Preliminary Acceptance Punchlist
El Paso County – Department of Public Works - Stormwater Section

Project Name:	Glen at Widefield F11
EDARP Filing Number(s):	ESQ2235
ESQCP Number:	SF204, CON2242
Attendees:	DPW SW: Natasha Grimaldo, Christina Prete, and Shannon Mustoe DPW Development Services: Brad Walters, David Parkerson, Amanda Rivera, and Spencer Pirzadeh Developer: Rudy Cross and Ryan Watson
Date of Walk-Thru:	04/10/2024
Walk-Thru Number:	1 st

SHEET
11
11 of 30 Sheets

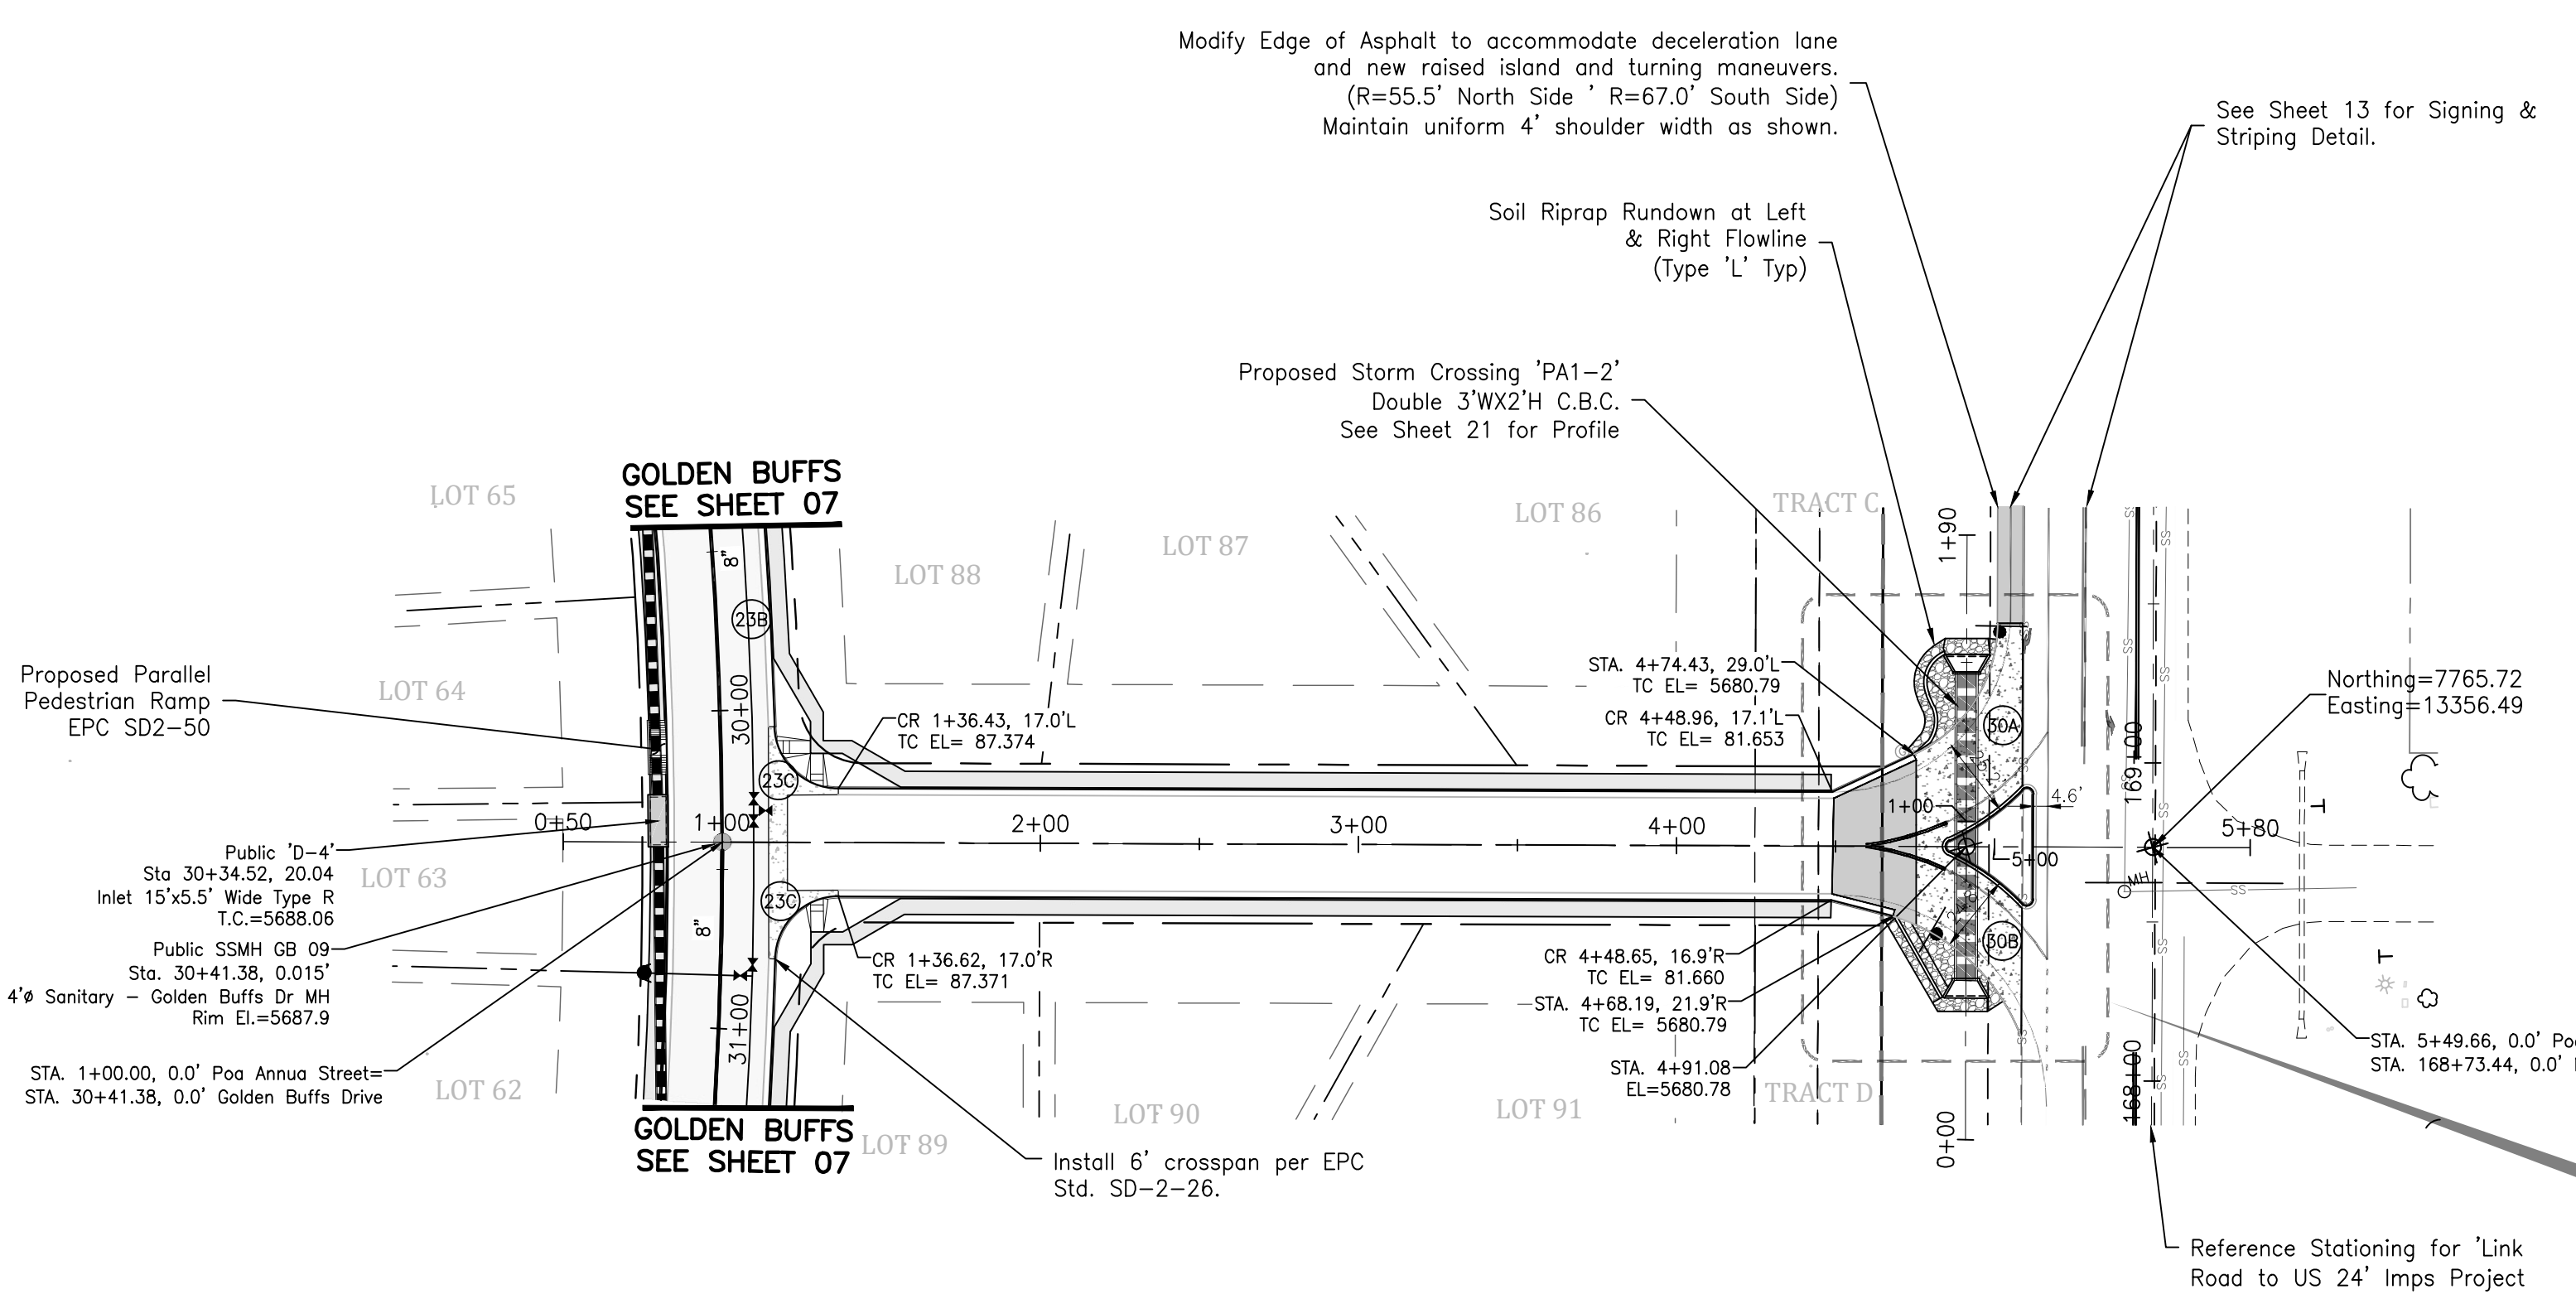
- Install riprap rundown at left and right flowlines. Reference Sheet 11 of the Construction Drawings. Reference Photo 4.
- Install Type M riprap pad at culvert inflow point. Reference Sheet 29 of the Construction Drawings. Reference Photo 5.
- Regrade ditch north of culvert to match preexisting conditions and stabilize. Reference Photo 6.
- Fine grade culvert outfall and downstream swale to allow for positive drainage and stabilize. Reference Photo 7.
